### **Application by AQUIND Limited for an Order granting Development Consent for the AQUIND Interconnector Project**

#### **Agenda for Issue Specific Hearing 3 dealing with Environmental Matters (ISH3)**

<b>Title of meeting</b>	AQUIND Interconnector Issue Specific Hearing on Environmental Matters
<b>Date</b>	15 December 2020
<b>Time</b>	10.00 am
<b>Venue</b>	Online via Microsoft Teams invitation
<b>Attendees</b>	Invitees

DRAWING NO: EN020022-ES-24.2-Sheet5	REV.NO. 01
---	---------------

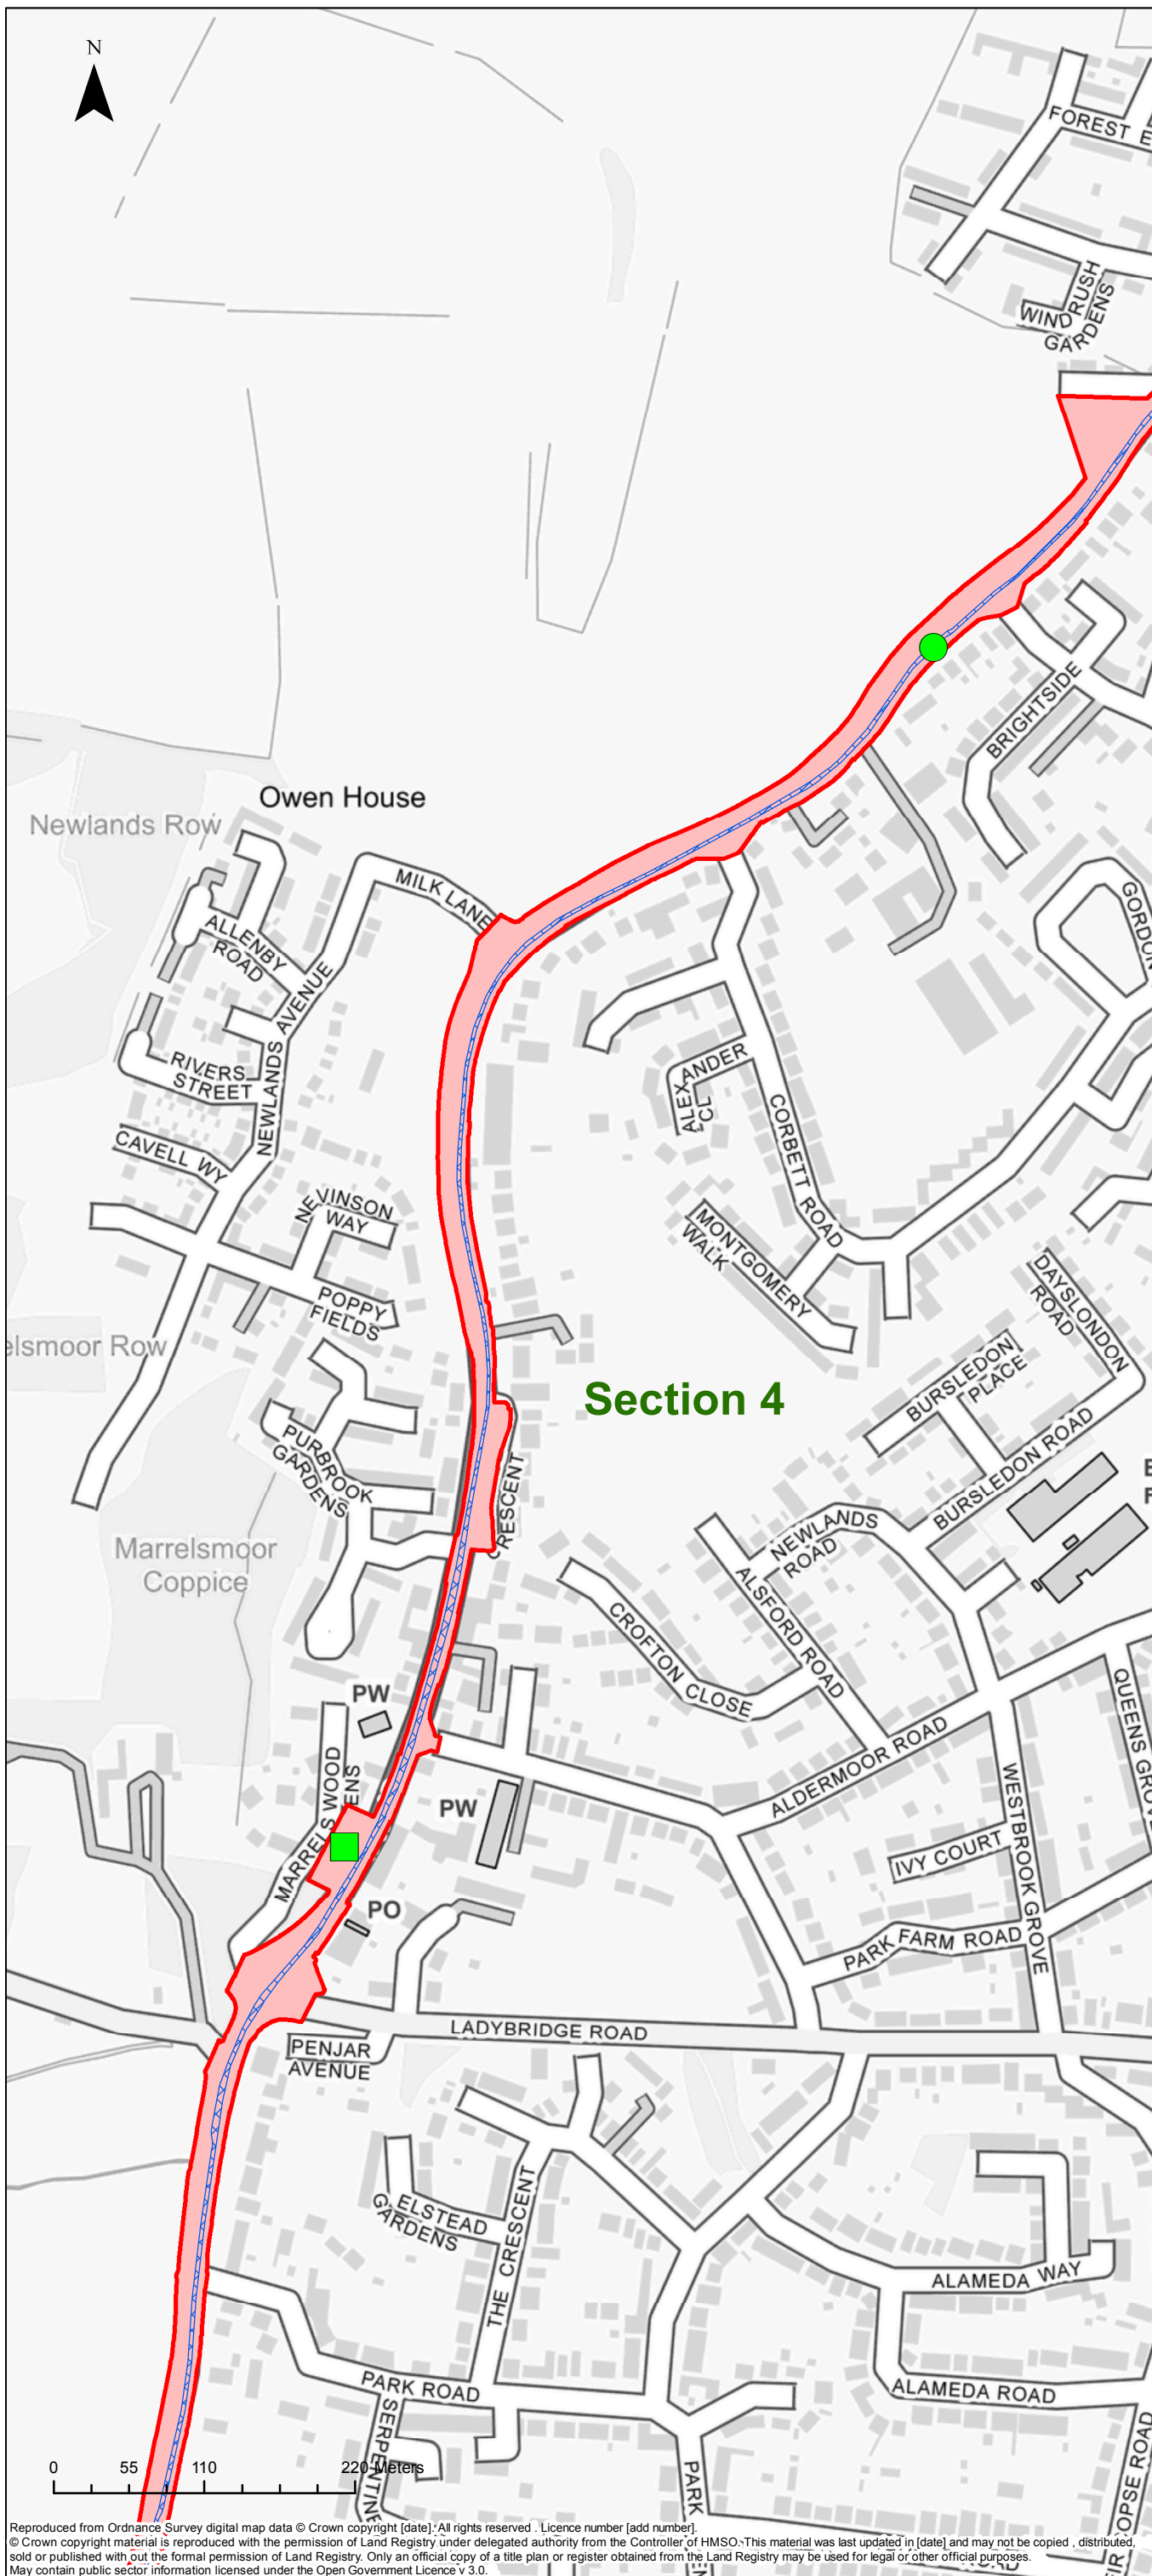
- With reference to ExQ1 N1.11.3, could the Applicant clarify the meaning of its response: *'Within the onshore cable corridor, the relative distance between the illustrative cable route and the noise sensitive receptors influences the magnitude of noise level experienced by any receptor. The magnitude of impact and overall noise effect assigned to this magnitude of level is influenced by the duration, timing and frequency of exposure to that noise level, which is not altered by the alignment of the cable route.'* The first part suggests that the distance between the cable installation and a receptor does influence the impact perceived at the receptor, as might intuitively be expected as noise diminishes with distance from source. The second part could be taken to contradict this. Notwithstanding the ultimate judgement of whether such an impact is significant or not, could ExQ1 N1.11.3 be reconsidered in respect of the different effects that might be perceived at sensitive receptors near those stretches of the route where it would be possible for installation to come substantially closer than the illustrative route?

- How robust is the assessment of magnitude of change in the noise environment and the determination of significance in the light of this? How does it relate to the adopted EIA approach of assessing the worst case?
